Date: 31st July 2019
Your Ref: PP-08028964
Our Ref: GB/AOL

APPLICATION UNDER SECTION 96A OF THE TOWN AND COUNTRY PLANNING ACT 1990 (AS AMENDED) – NON-MATERIAL AMENDMENT TO PLANNING PERMISSION REFERENCE LU/59/19/PL AT WATERSMEAD BUSINESS PARK, NORWAY LANE, LITTLEHAMPTON

PROPOSED FLOOR PLANS

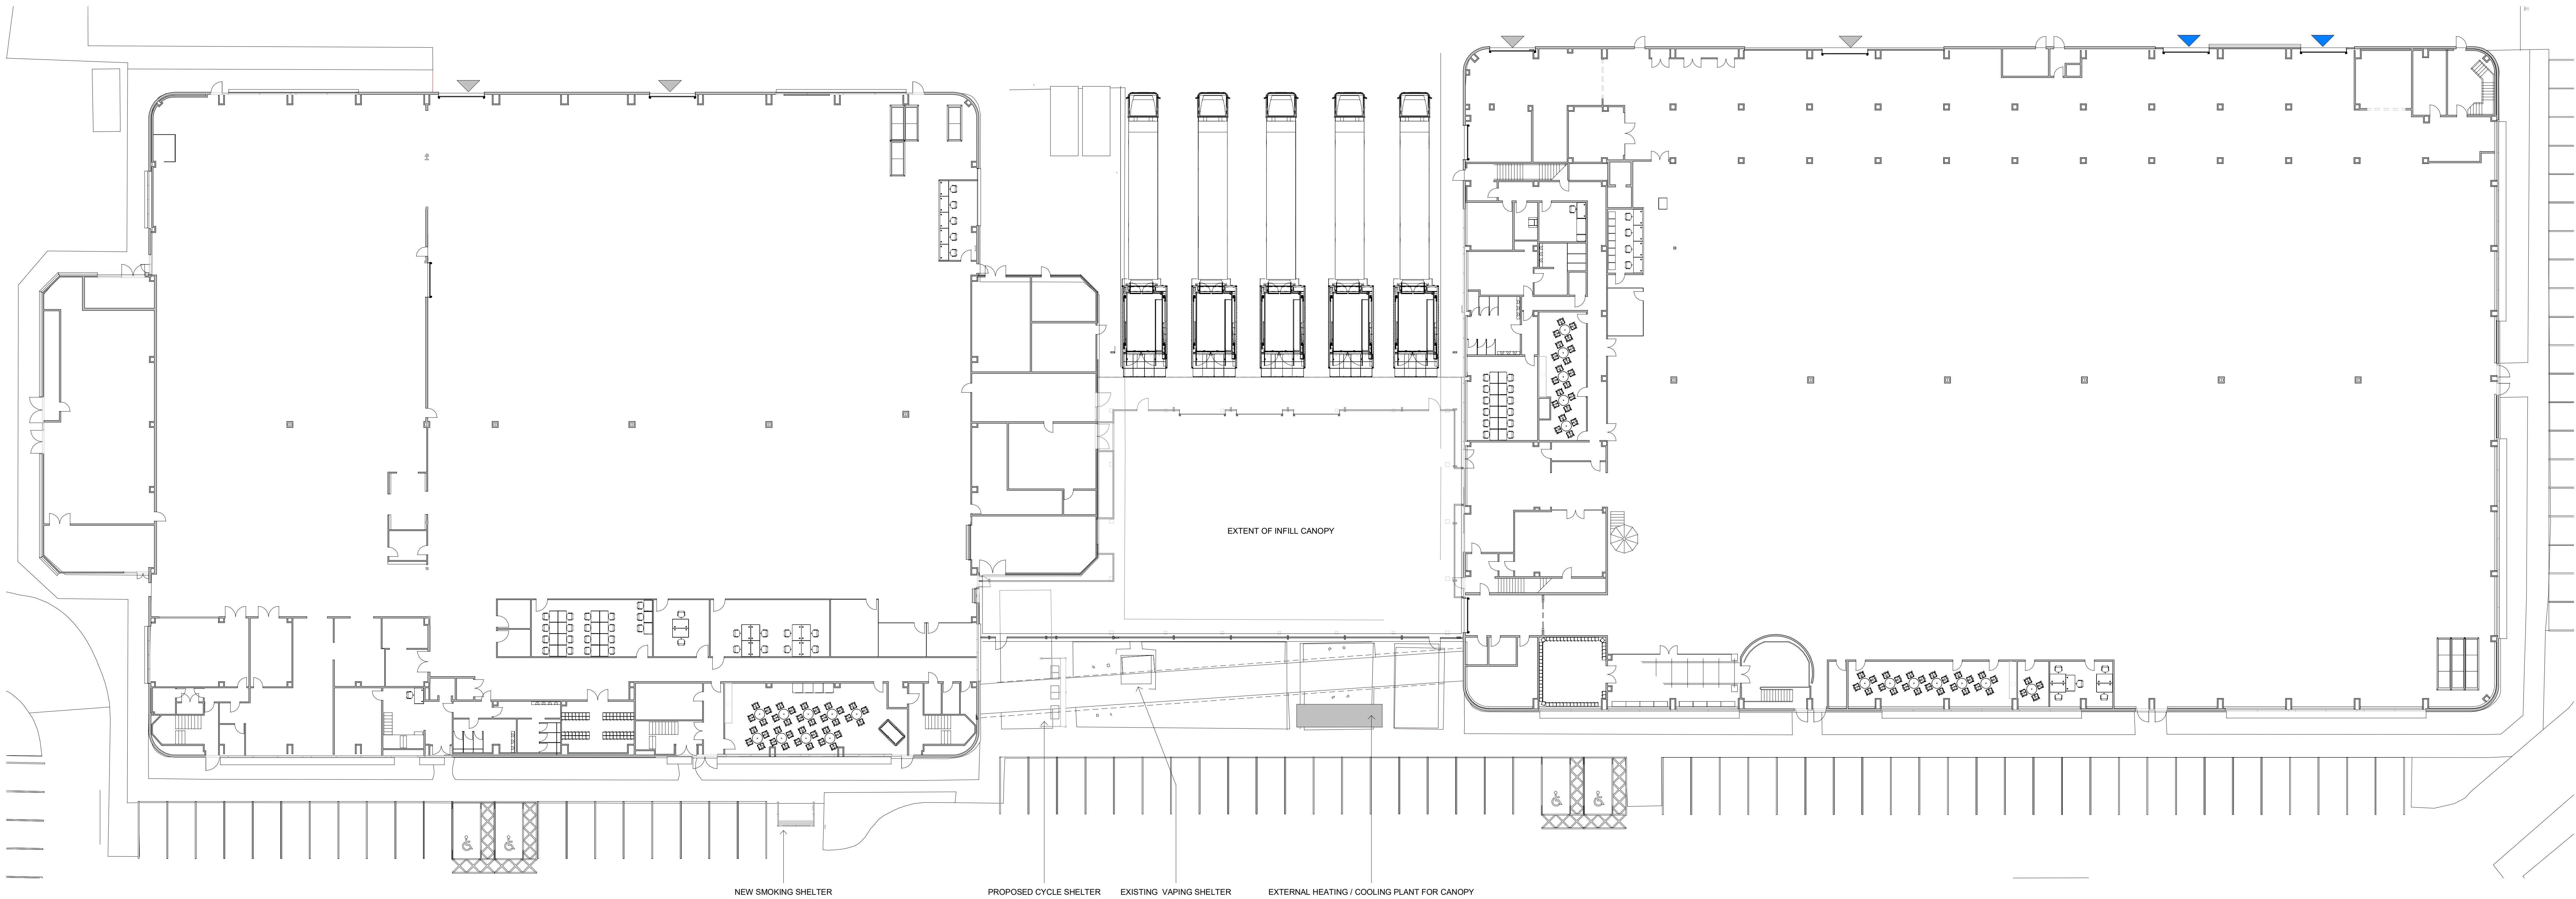
- Installation of an ATS cart canopy at the north east corner of 'Building 5';
- Re-provision of the existing cycle shelter in its current location; and,
- Re-provision and relocation of the existing smoking shelter from the north east corner of 'Building 5' to the south east corner of 'Building 5'.

- Application form (including Certificate of Ownership);
- Proposed Site Block Plan (ref: 7260-SMR-00-ZZ-DR-A-2001-S3-P10);
- Proposed Floor Plan (ref: 7260-SMR-00-ZZ-DR-A-2007-S3-P4);
- Proposed External Details (ref: DBN3-SMR-00-ZZ-DR-A-2010-S3-P3); and,
- Proposed Non Material Amendment Site Plan (ref: DBN3-SMR-00-ZZ-DR-A-2102-S3-P2).

- Proposed Site Block Plan (ref: 7260-SMR-00-ZZ-DR-A-2001-S3-P9);
- Proposed Floor Plan (ref: 7260-SMR-00-ZZ-DR-A-2007-S3-P3);
